RE: DRAINAGE PLAN FOR ADDITION TO GARDNER-ZEMKE
RECEIVED FEBRUARY 4, 1986 (F-17/D39)

**RE: PHASE III MODIFICATION TO MINI-STORAGE WAREHOUSES (F17-D39).
GRADING AND DRAINAGE PLAN MODIFICATION. ENGINEER'S STAMP
DATED MAY 18, 1998.**

RE: BUILDING PERMIT FOR MINI-STORAGE WAREHOUSES (F17/D39) ENGINEER'S
STAMP DATED 11/23/93.

DETAIL A - RUNDOWN CHANNEL INLET

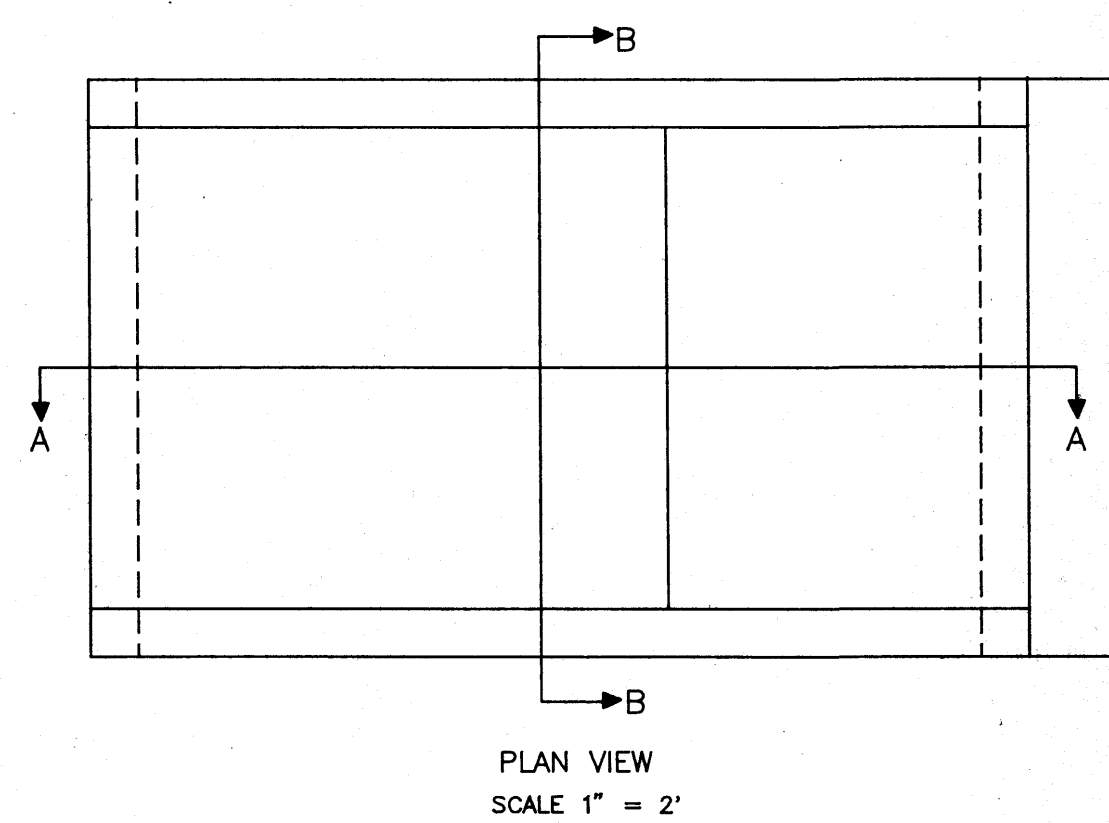
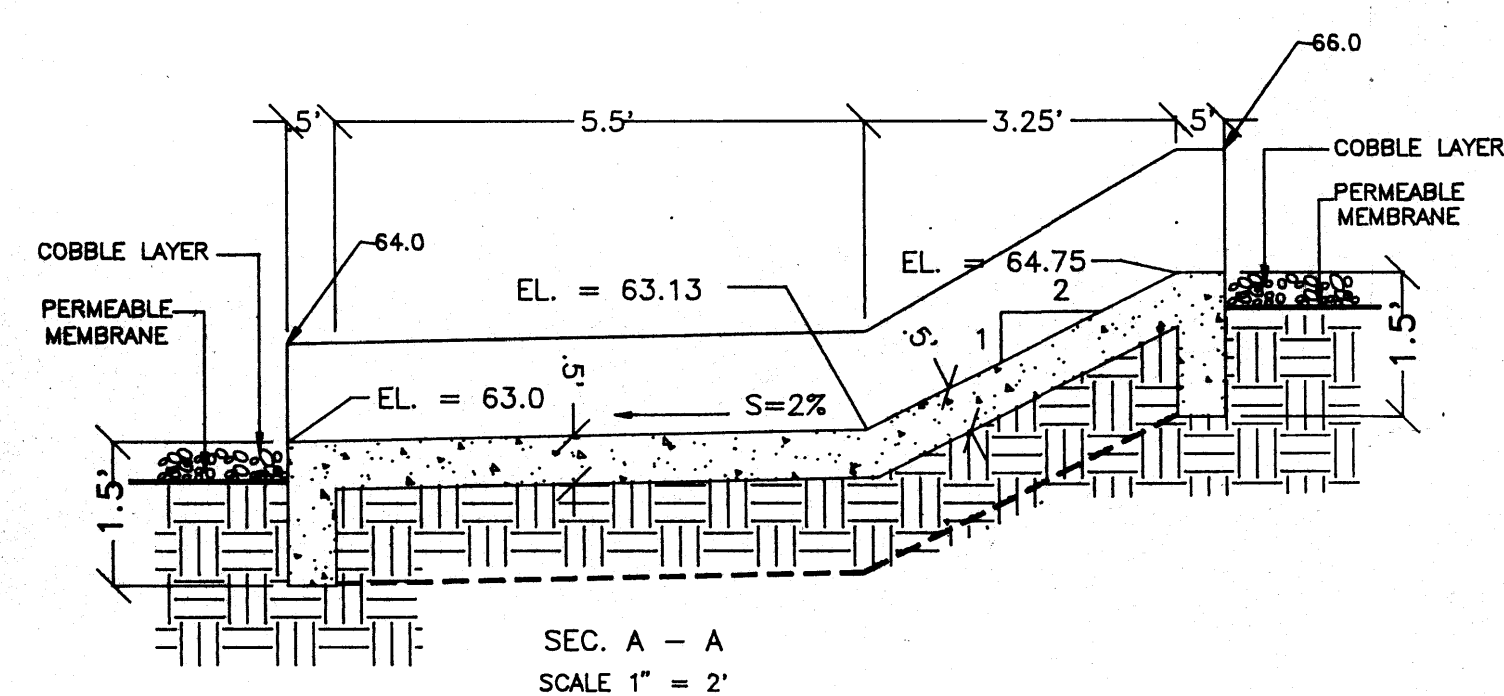
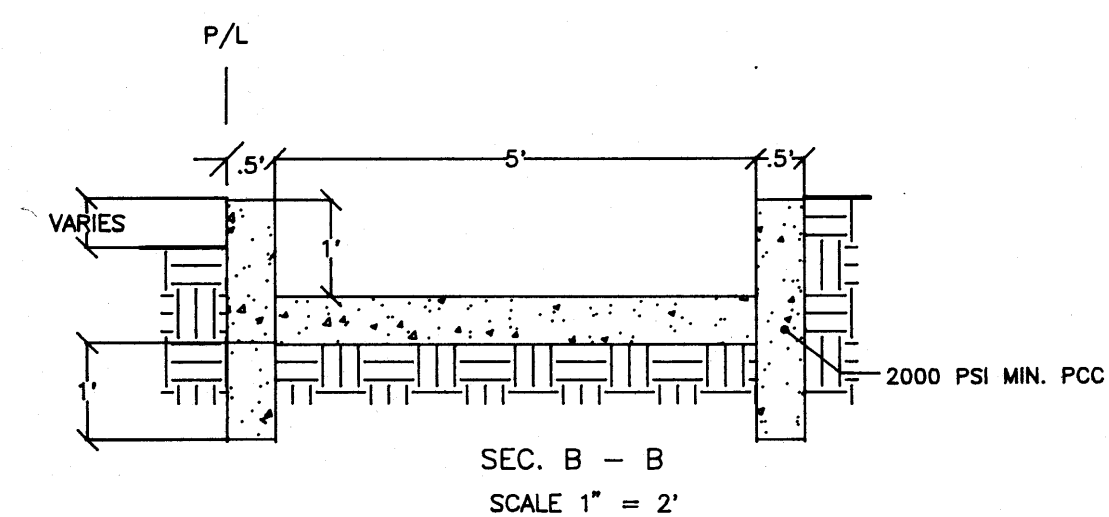
7. I am concerned that storm water in a large event may pond at the top of the concrete rundown shown in Detail A. If this were to occur, storm water may spill over the 6" curb onto the adjacent property. Please supply me with additional information concerning this area of the site.

PROPERTY OUTFLOW SECTION

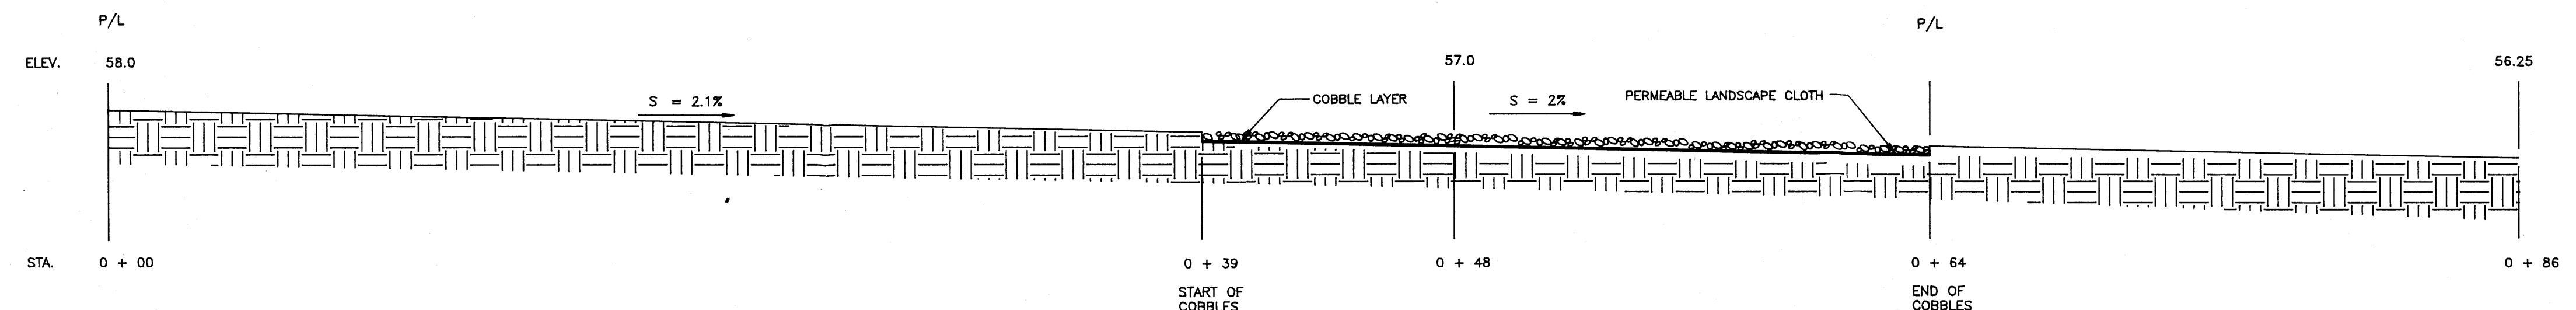
5. Details of the outfall from the ponding area to the downstream flow path.
6. A concrete rundown is shown outfalling from the I-25 Frontage Road onto your site. Since this same area is within a floodplain, I believe it is important to know to what extent your site will be impacted. An estimate of this flow is needed so that it can be determined whether special provisions should be made to protect the storage buildings adjacent to this area.

RUNDOWN CHANNEL OUTLET SECTION

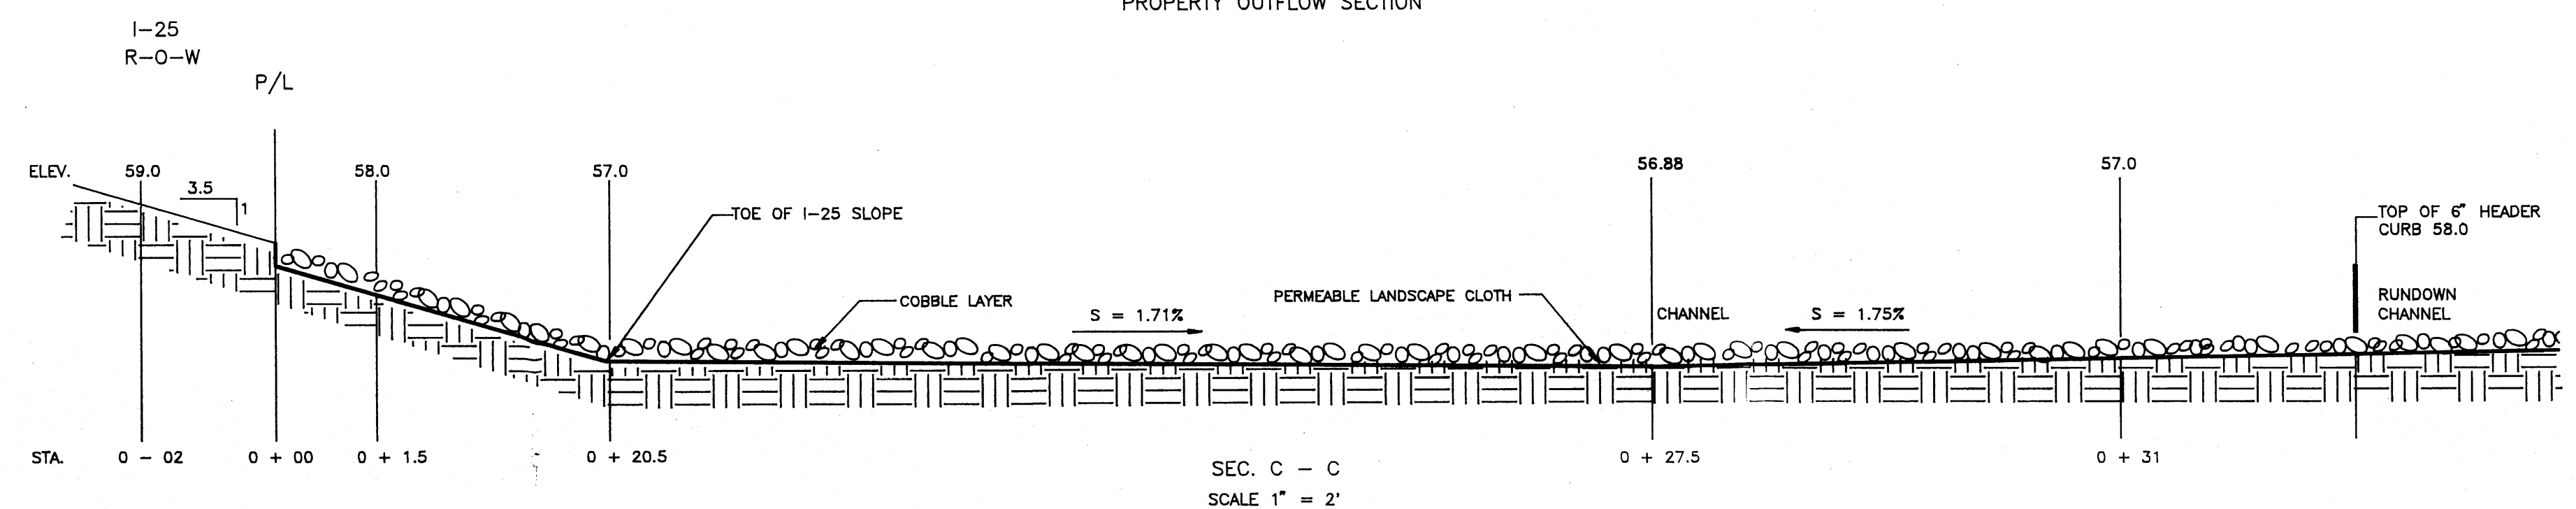
3. Details of the drainage channel along the south property line. A cross-section would suffice.
4. Details of the outfall from the above mentioned drainage channel to the ponding area on the southwest corner of the site.
